RE: **Sunset West-Unit III**
920 Suneast Dr, 8700 & 8704 Sunbow Ave. W
Pad Certification for lots 17P-1, 18P-1 & 19P-1, Block 2 - Approved
Engineers Stamp Date 8/26/10 (L09D012A)
Certification Dated: 10/20/16

**Re: Sunset West Unit III Lots 17, 18 and 19 Grading and Drainage Plan
Engineer's Stamp date 8-26-10 (L09/D012A)**

**Re: Sunset West Unit III Lots 17, 18 and 19 Grading and Drainage Plan
Engineer's Stamp date 7-26-10 (L09/D012A)**

SUNSET WEST UNIT III LOTS 17, 18 AND 19
GRADING AND DRAINAGE PLAN

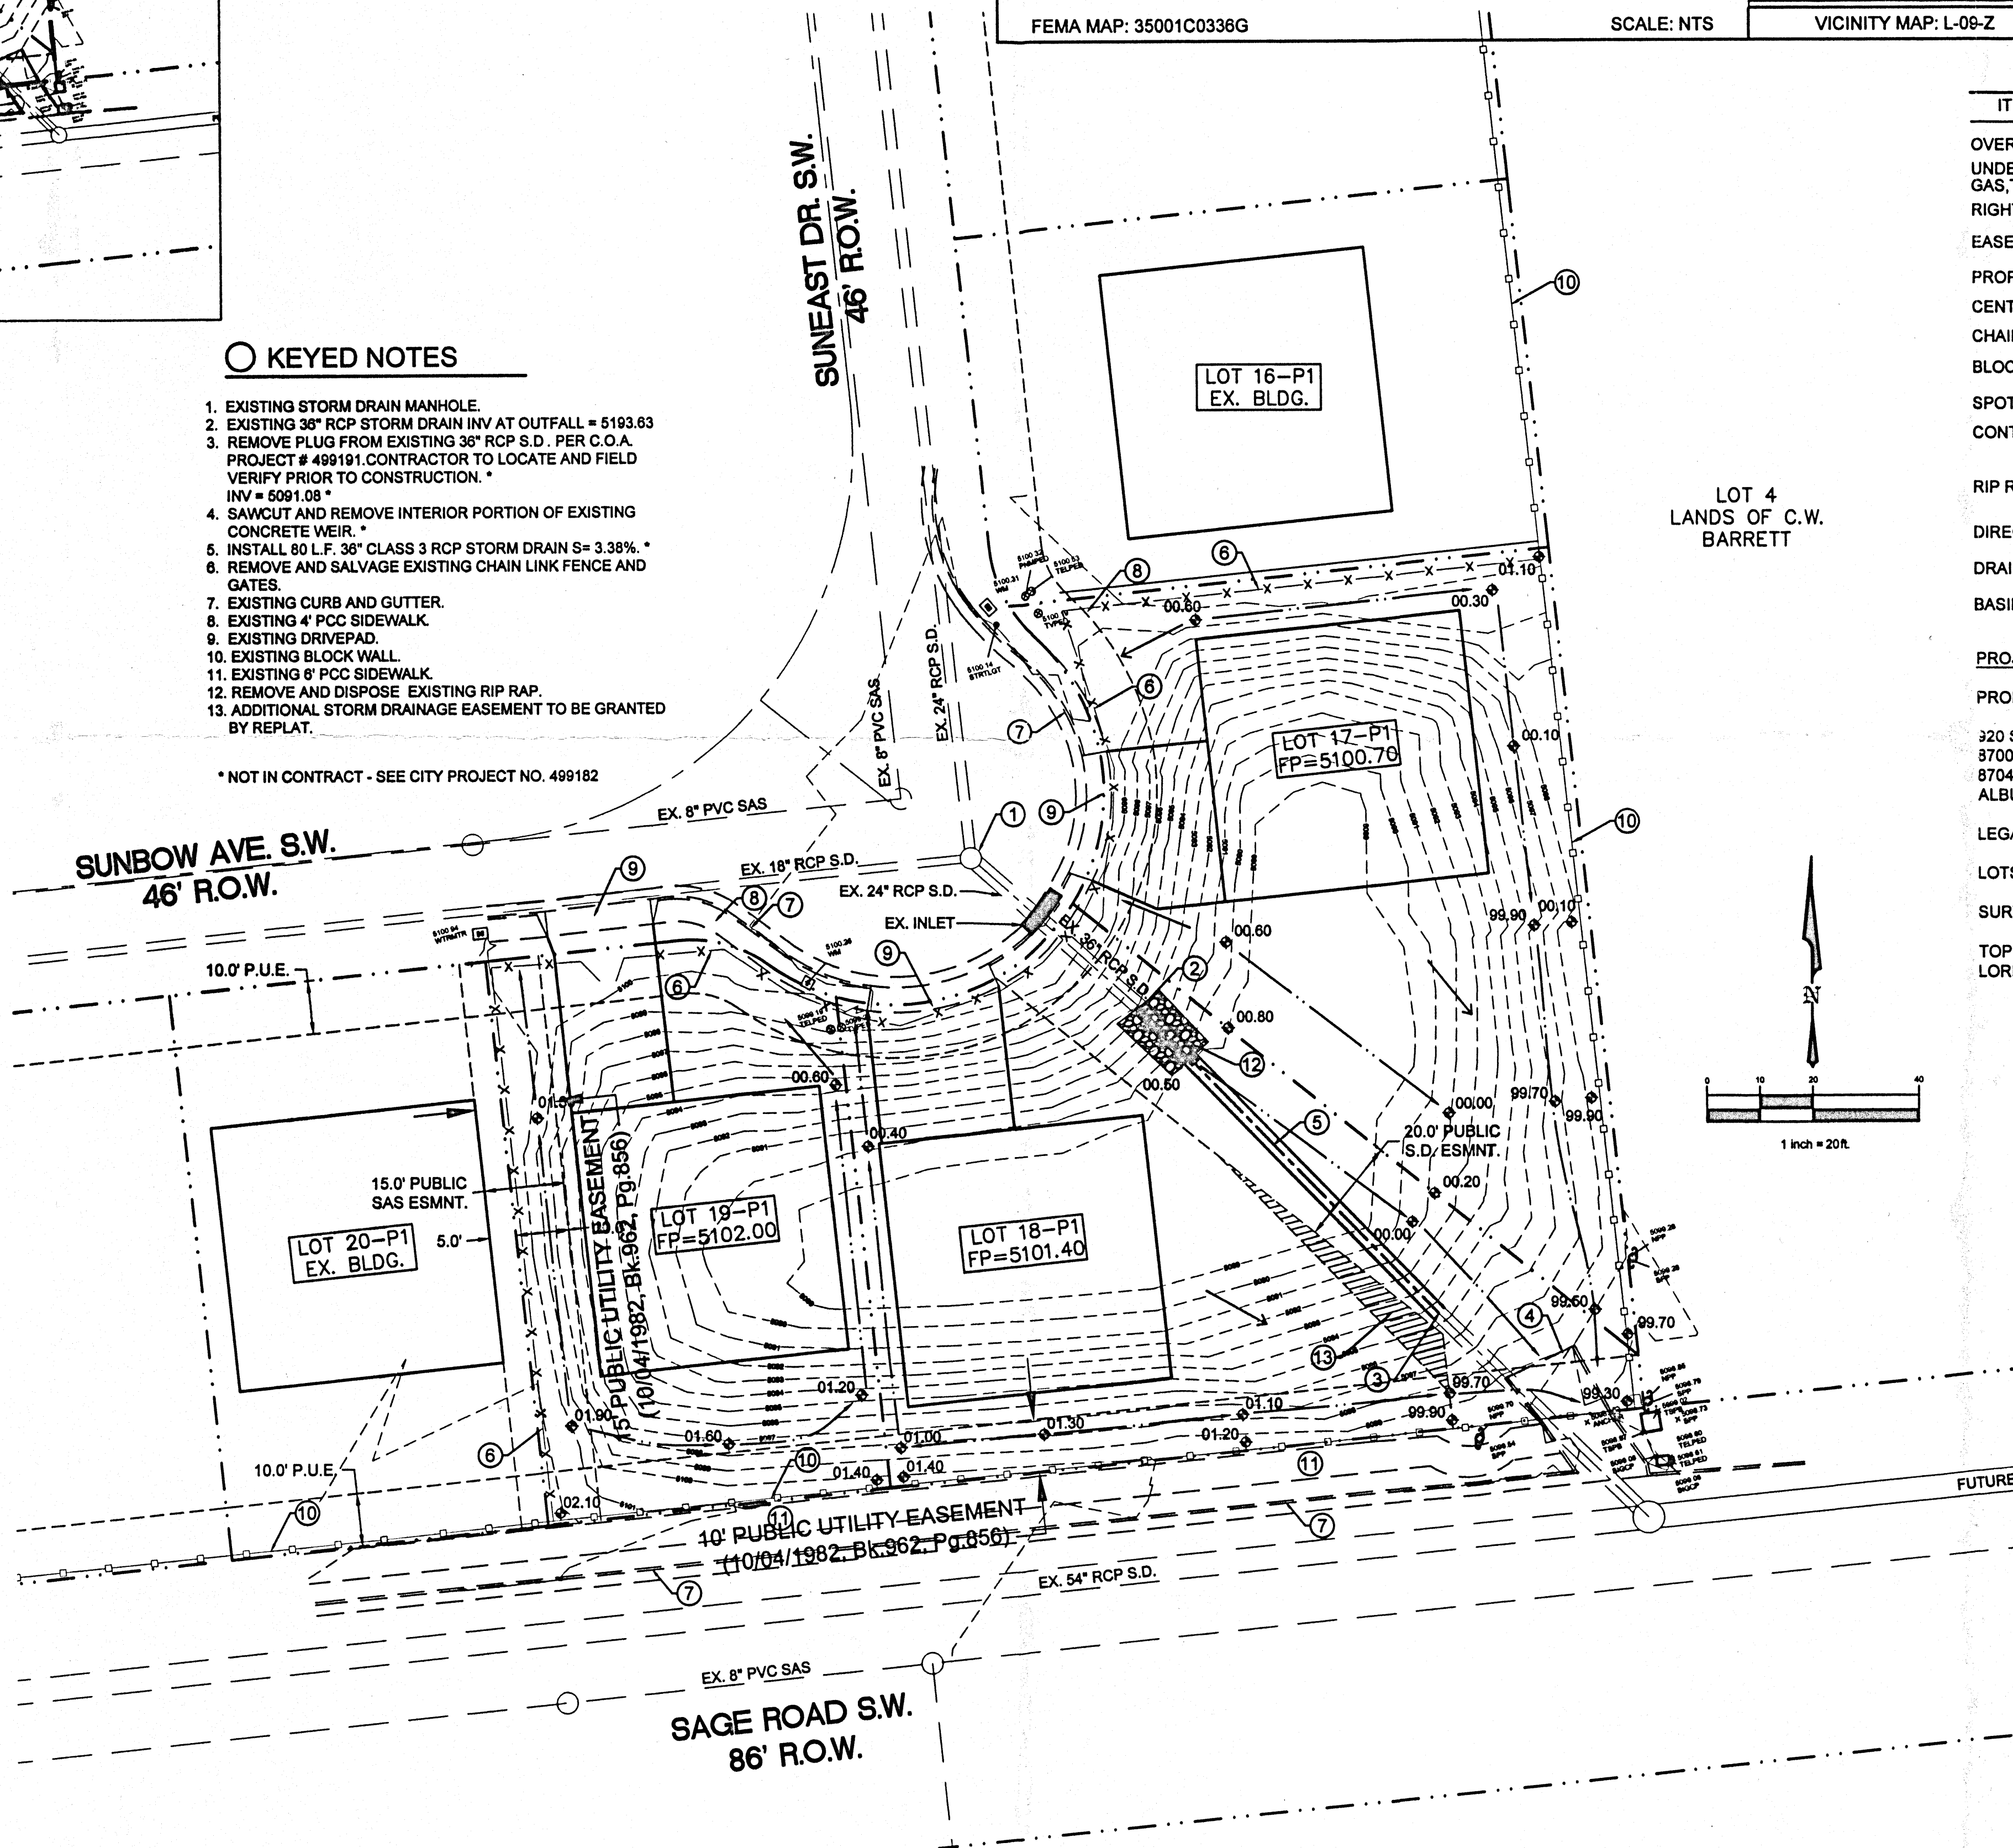
- Provide as-builts for the downstream storm drain.
- All work in the storm drain easement is to be done per Work Order. Lot grading could be done per a Grading Plan. Change Keyed Notes 3, 4, 5, and 12 to reflect that these items are to be performed by Work Order.
- The additional storm drain easement will need to be granted prior to approving the Work Order.

Submitted herewith for is one copy of the Revised Grading and Drainage Plan for the subject project. The Plan has been revised to address your comments issued July 29, 2010. Specifically, your comments are addressed as follows:

1. We understand that Work Order will not be issued until completion of the 86th/Sage Storm Drainage Project.
2. The Keyed Notes have been revised to identify public-vs-private work items.
3. The existing Temporary Public Drainage Easement on Lots 17-p1 thru 19-p1, Unit 3 must be vacated by replat. Also, additional Public Storm Drainage Easement will be granted by replat for the 36-inch storm drain.
